Subject: Fwd: Planning Application 3/2024/0184-- Hillside, Moor Lane

Subject: Planning Application 3/2024/0184-- Hillside, Moor Lane

BDP JOB NUMBER P0054	ISO 27001 CLASSIFICATION Planning
DRAWING TITLE Roof Plan	SCALE @ A3 1 : 75 DATE FIRST ISSUED 29/02/24
DRAWING No. HLS-RALA-ZZ-XX-DR-A-(BR)-0005	REVISION P01

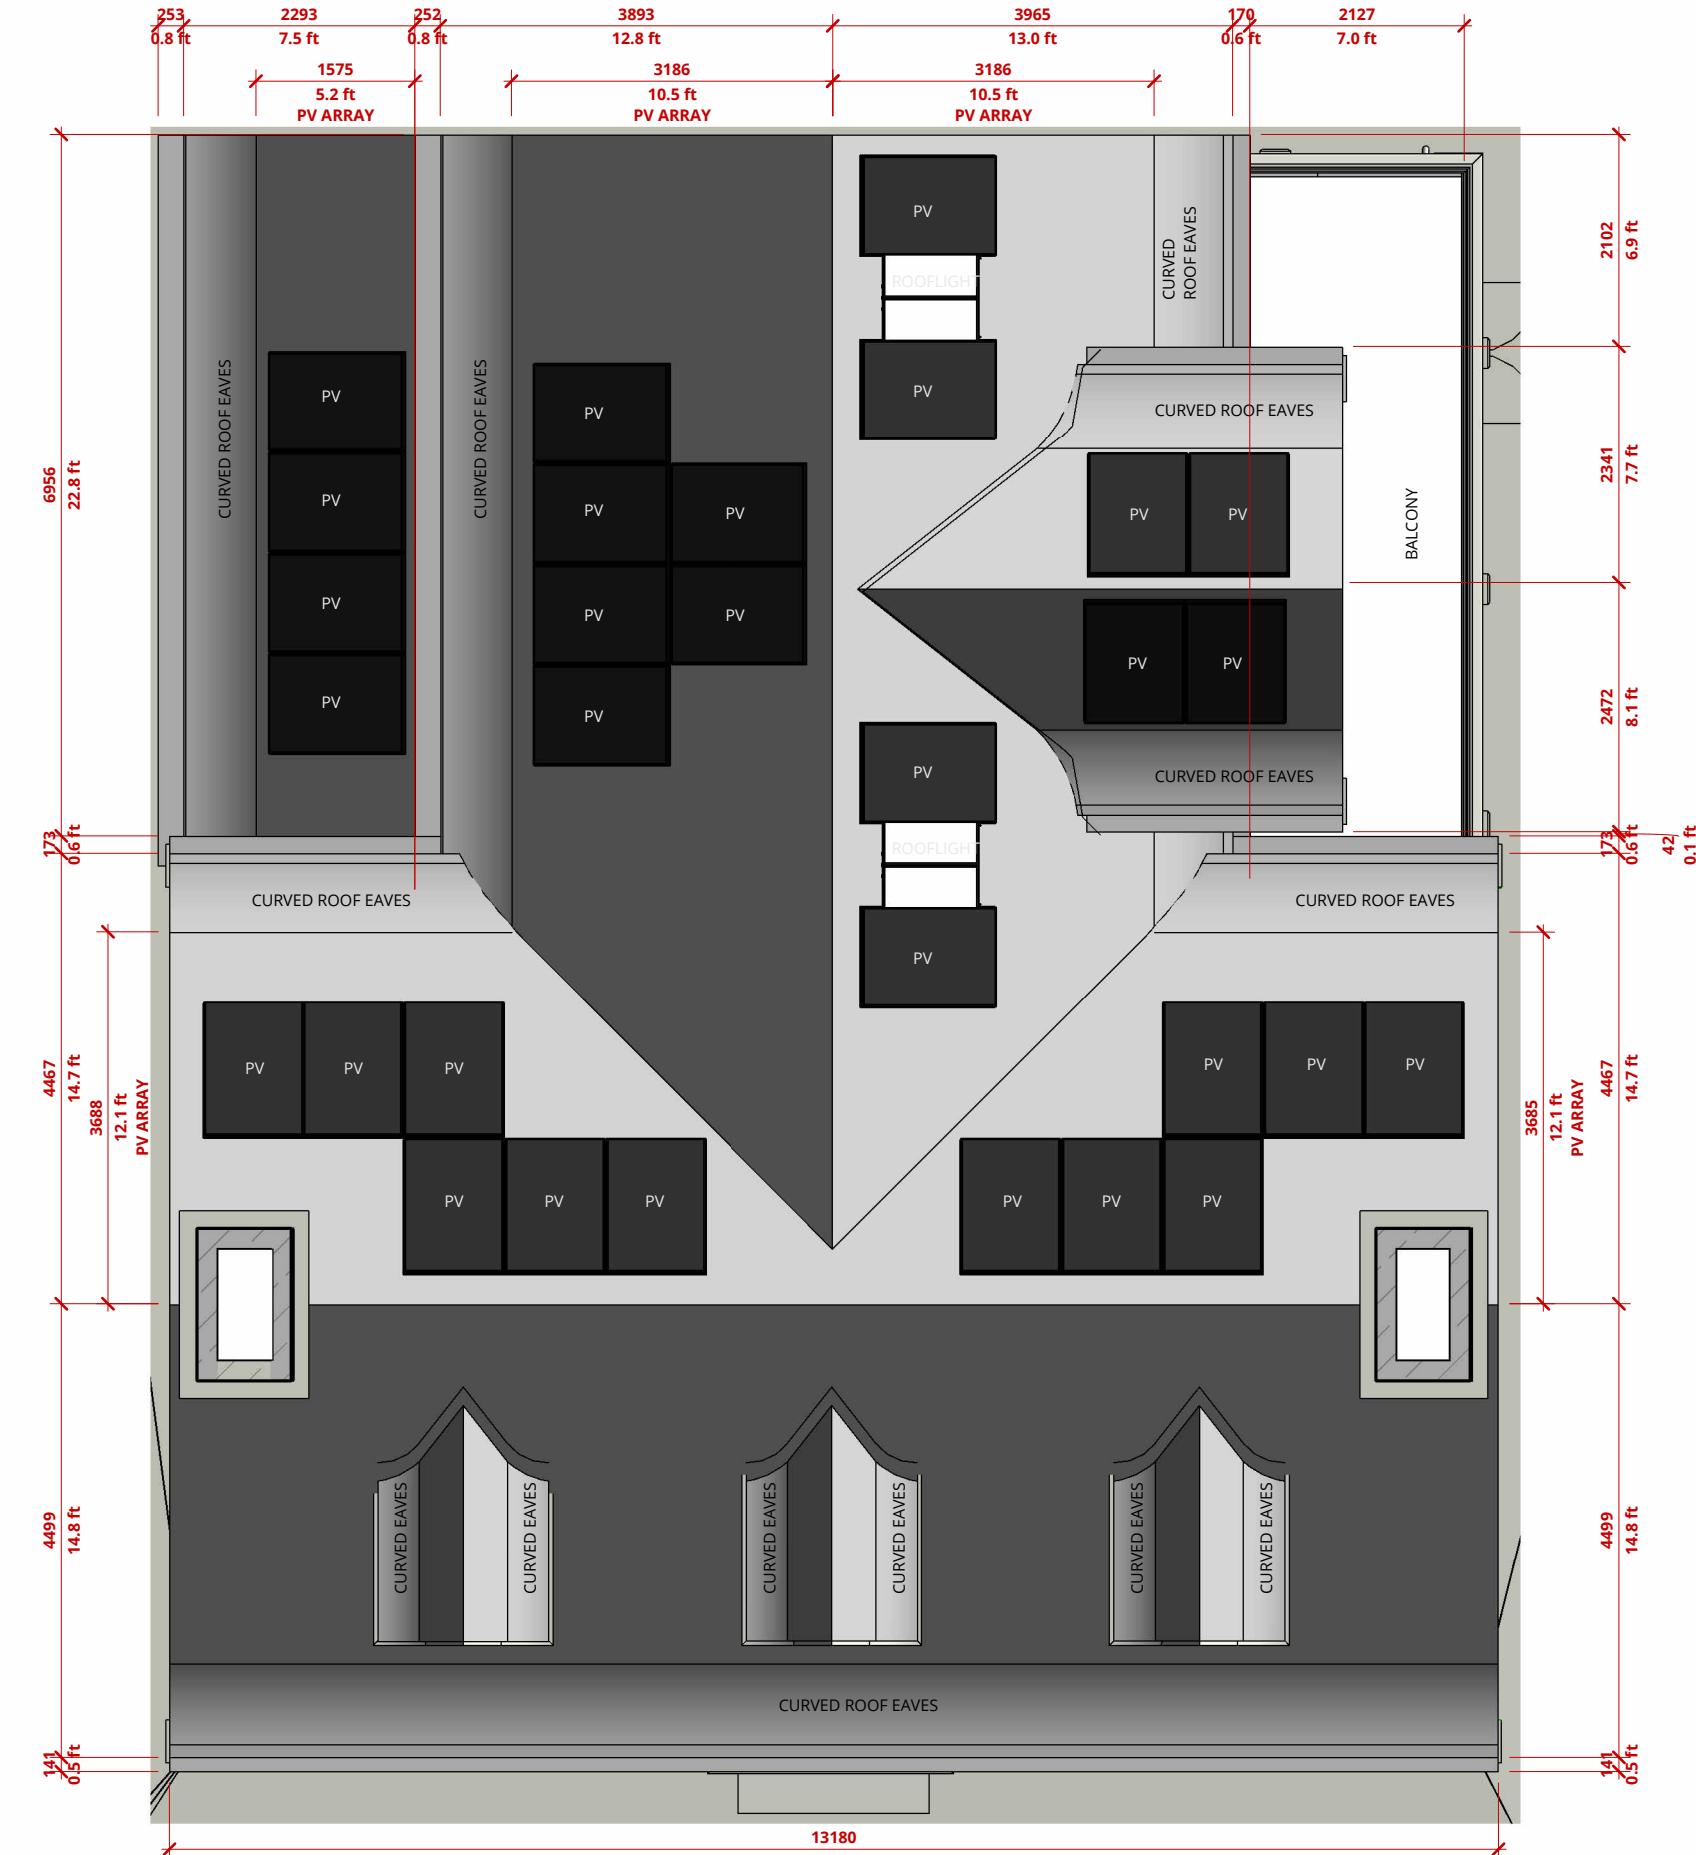
When we reviewed the original plans one specific point we looked at was the height of the property compared to that of the original bungalow which has now been demolished. Our understanding was that the new property was being moved down the site so that whilst the building was to be taller the ultimate height was no greater and therefore the [REDACTED] would not be affected. This remains important to us but we could not from the new plans be sure that this remains the case.

Fig 02. Laydown area

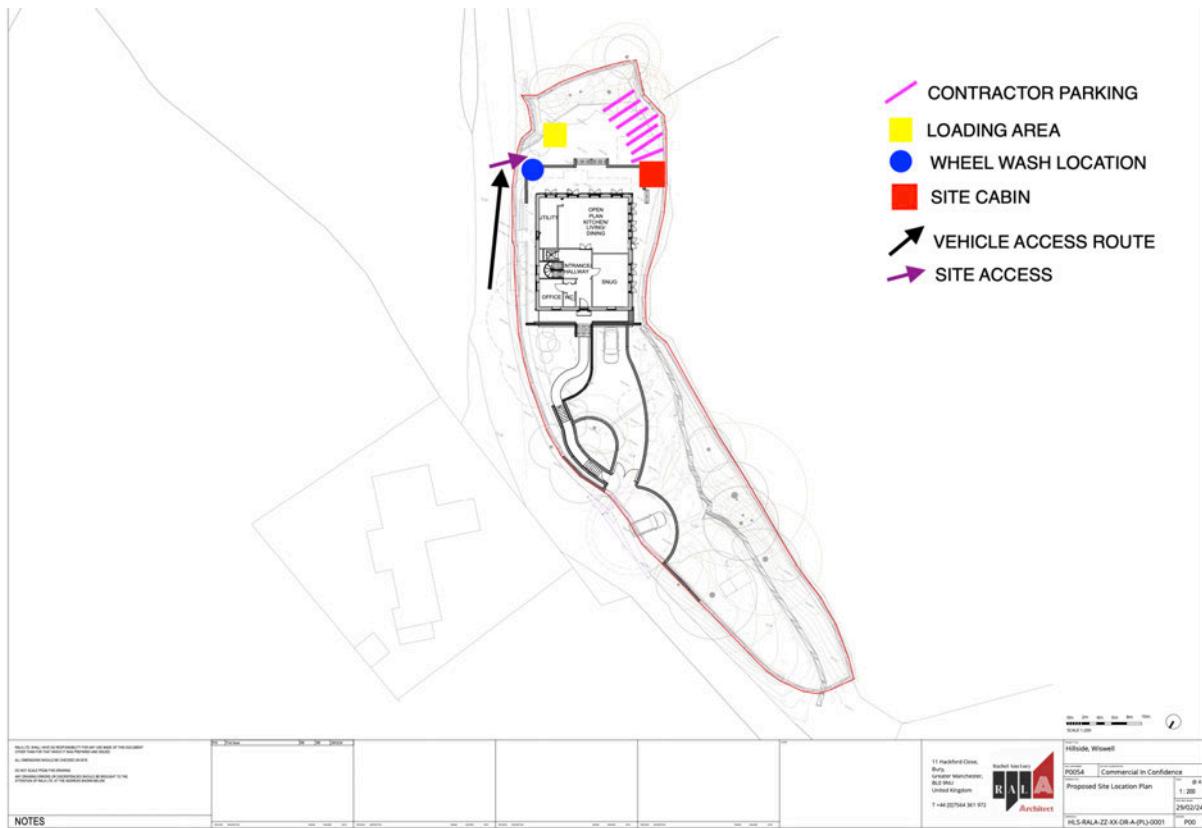
The other issue we would wish to raise is to ensure that, during the construction phase, access up and down the road is maintained at all times. [REDACTED]

[REDACTED] and cannot be late for etc. Even to date we have been inconvenienced by [REDACTED] lane is single file and therefore there needs to be a plan to manage this. We thought such a plan was a pre-condition to commencement of the works on site according to the planning permission under which works must have commenced but we have not seen or been consulted about the same which concerns us. [REDACTED]
